# CROSSROADS AT MEADOWBROOK-REZONE MAP

LOCATED IN THE SOUTHWEST 1/4 OF SECTION 8, T14S, R65W, OF THE 6th P.M., EL PASO COUNTY, COLORADO

# zoning V\_1map planning only comments.pdf Markup Summary 1-15-2021

CROSSROADS AT MEADOWBROOK-REZONE MAP

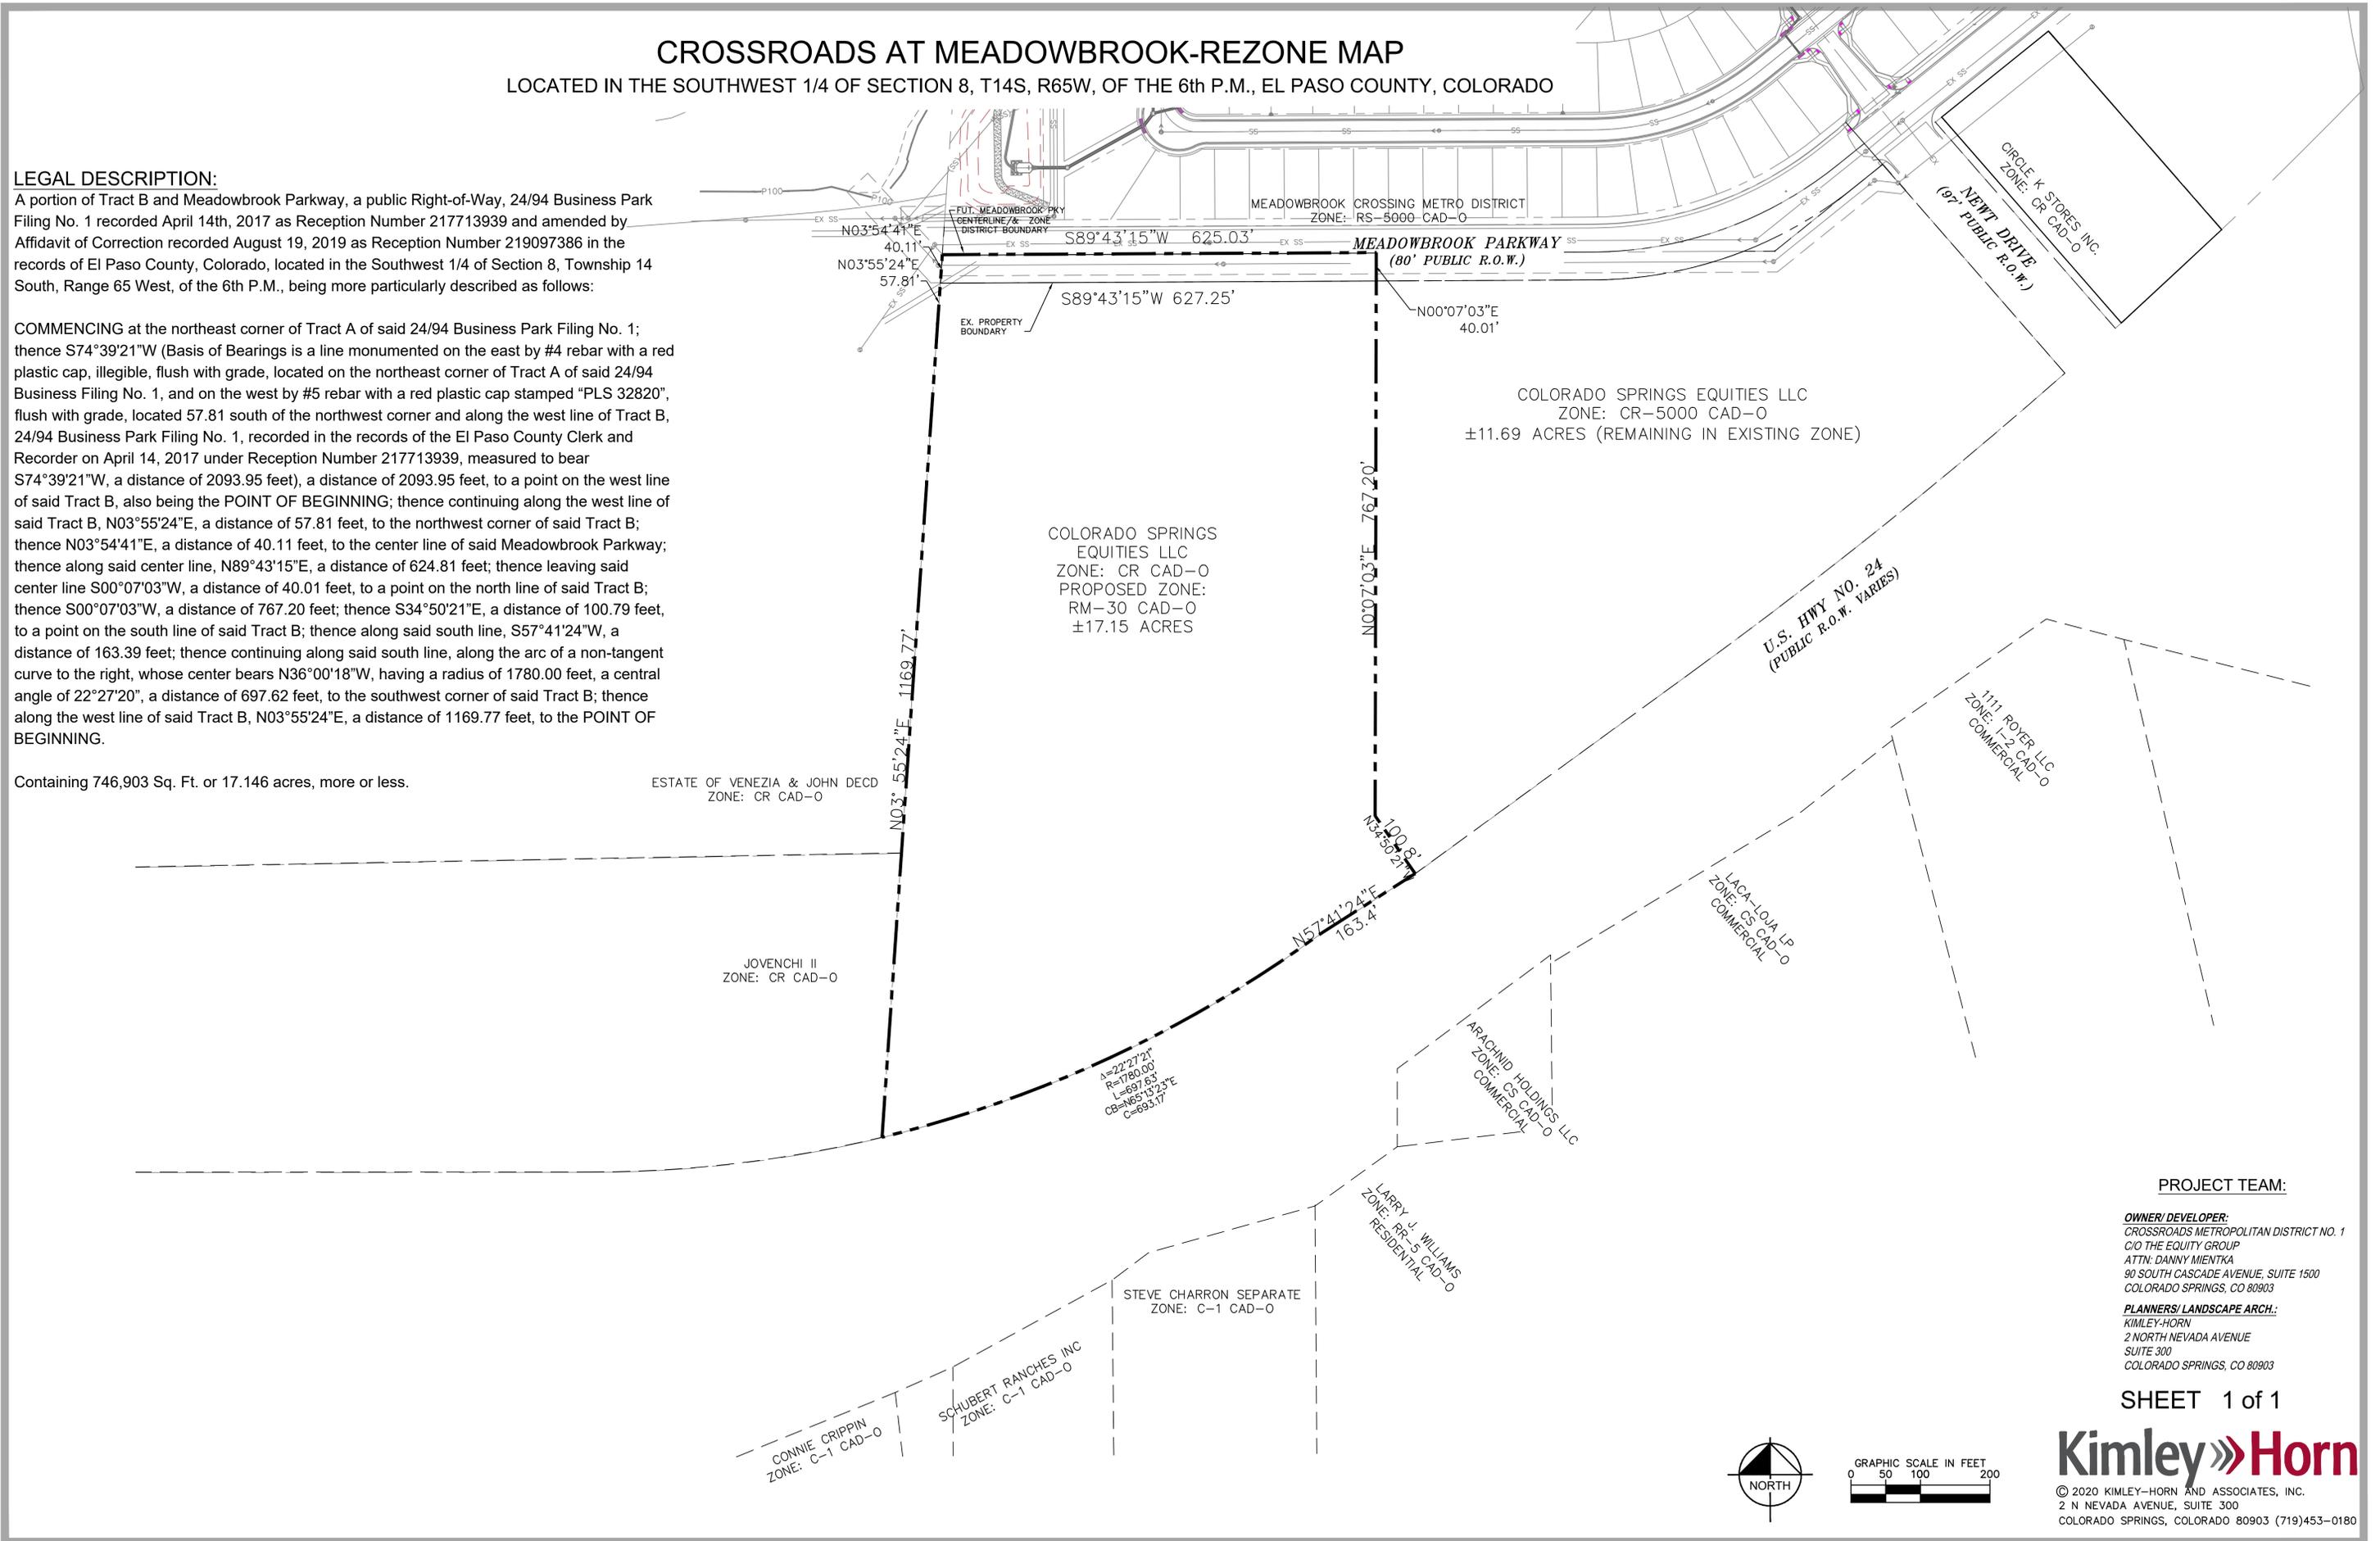
show the residential lots partially, and use, ownership, roads within 500 feet

LEGAL HERE

what is this line?  
zone to CL of roads

proposed acreage

easements?

double check this arrow
